**Planning application no: 3/2014/0010.**

**Proposal:** Erection of single storey extension to side and rear.

**Location:** 26 Holden Street, Clitheroe BB7 1LU.

PROPOSED GROUND FLOOR LAYOUT.

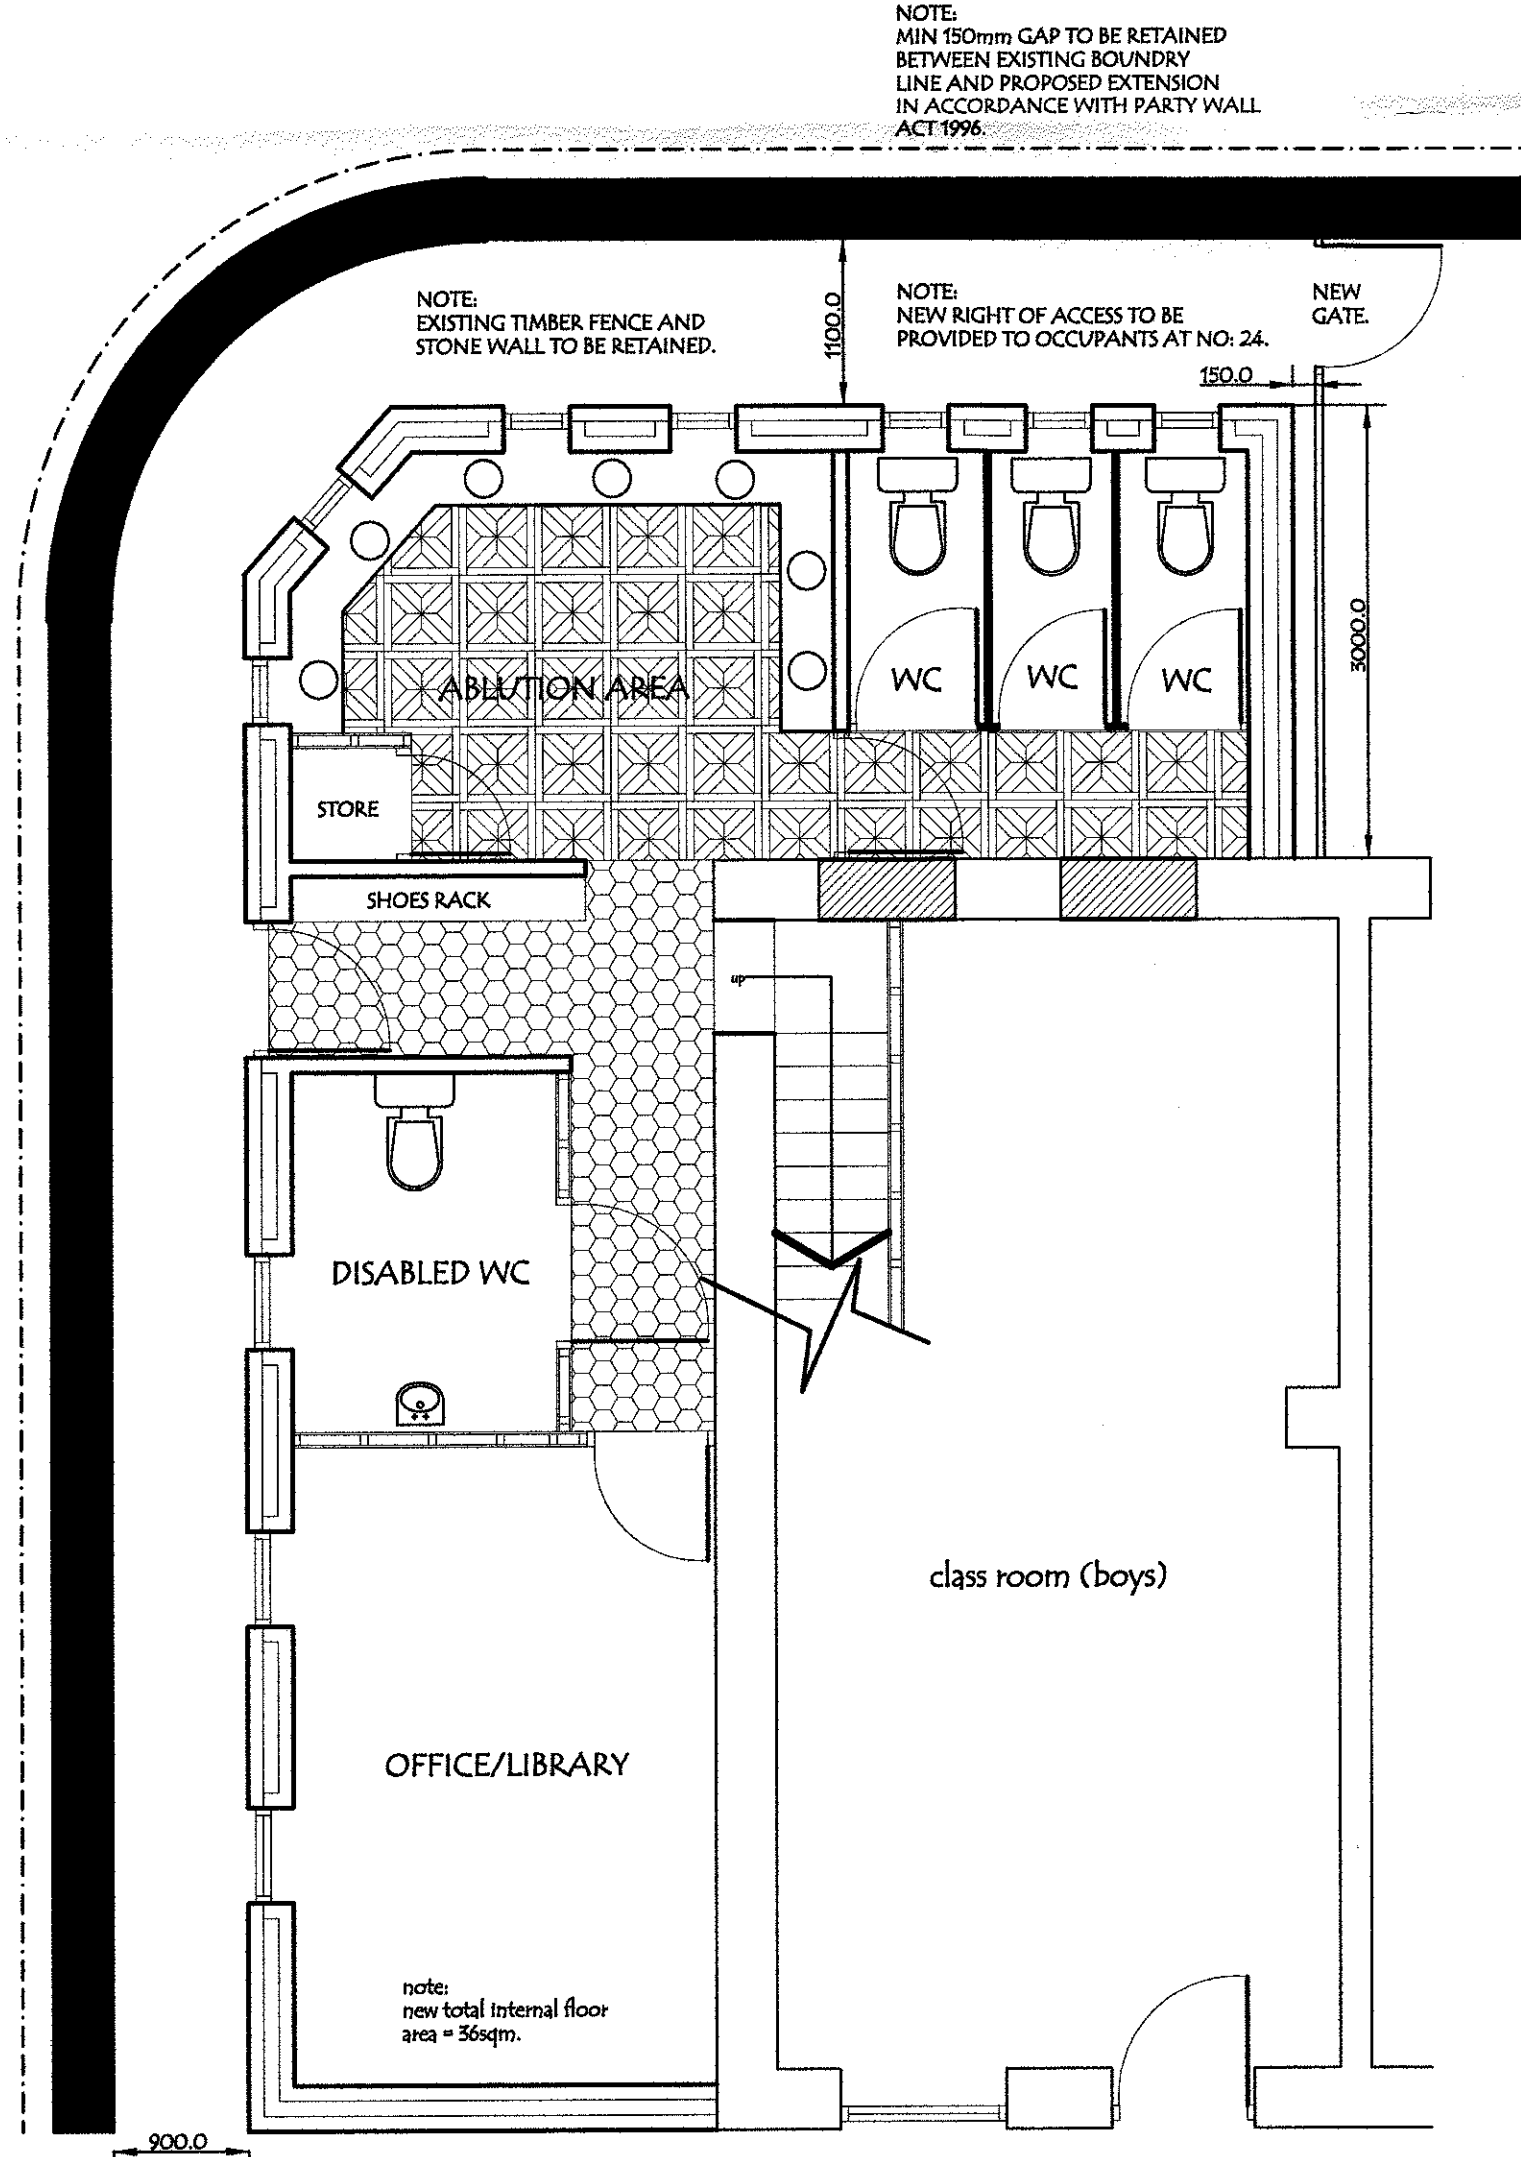
The portion of land on which the extension is proposed is partly adopted highway. The highway adoption would have to be lifted for this development to occur.

The application states that there is one parking space on this property at present. The proposed development will remove this parking and there will then be no on-site parking at this property.

In the absence of any discussion in the application papers regarding the parking that may be generated by this proposed development, I would ask for one additional parking space on site, to result in two on-site parking spaces in total. I consider this is appropriate having regard to the size of the proposed development (39 sqm in extent) and the demand for on-street parking for local residents in the vicinity.
